From: Nicola Oktay on behalf of Planning.Responses
Sent: 13 December 2023 09:40
To: Planning Scanning
Subject: FW: P/153/21/RES

From: Jonathan Best [REDACTED]
Sent: Tuesday, December 12, 2023 4:28 PM
To: Planning.Responses [REDACTED]
Cc: Jessica Riches [REDACTED]
Subject: P/153/21/RES

I have reviewed the updated details for P/153/21/RES.

drawing title
DETAILED ON-PLOT LANDSCAPE PLAN
(Sheet 2 of 13)

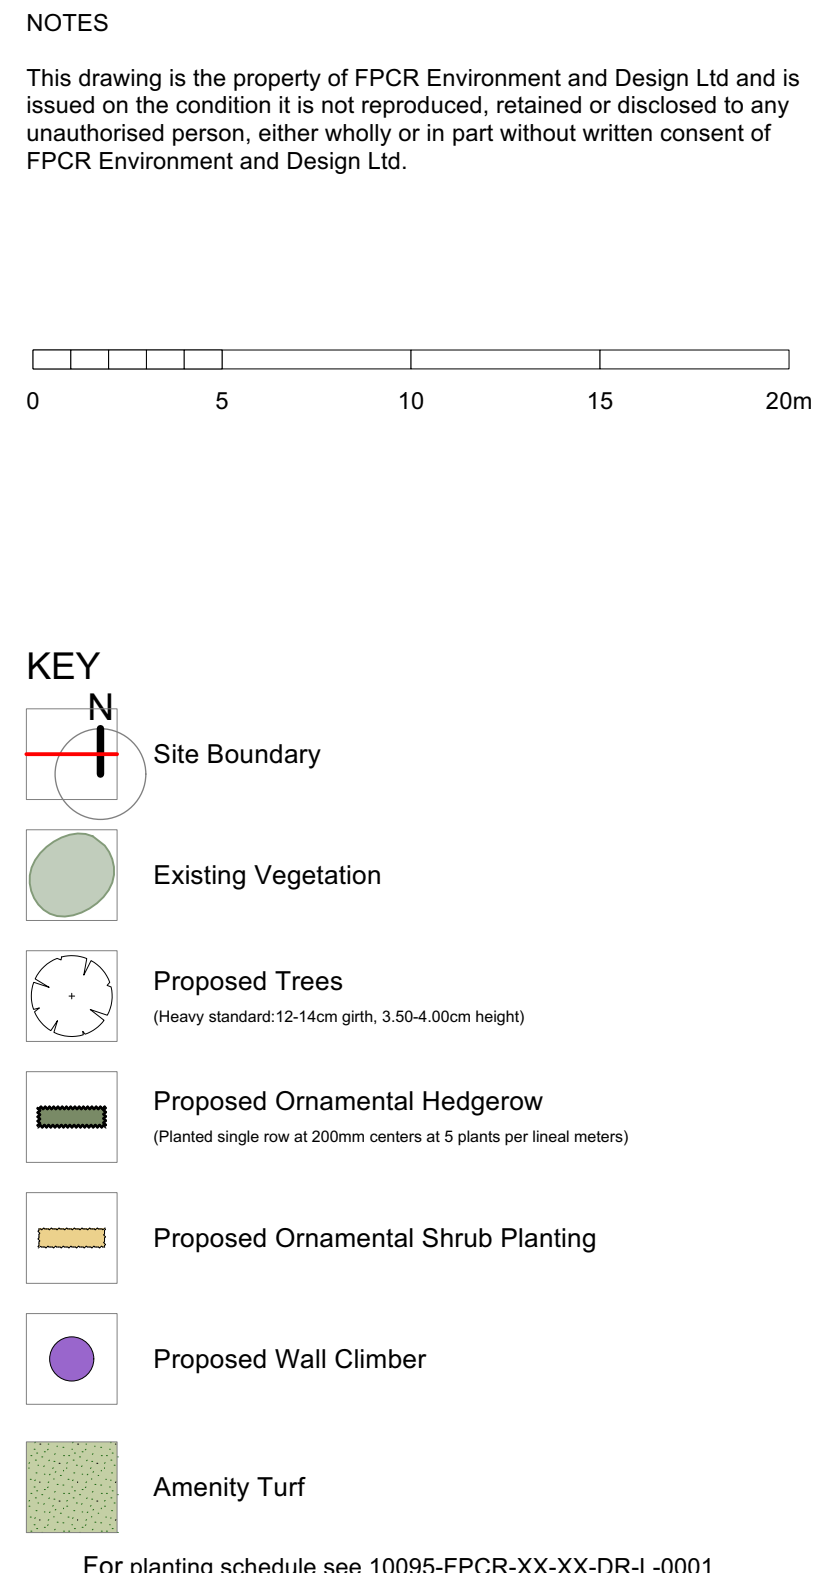
The changes to species are fine. I welcome the inclusion of the Elm New Horizon.

The wetland planting is fine.
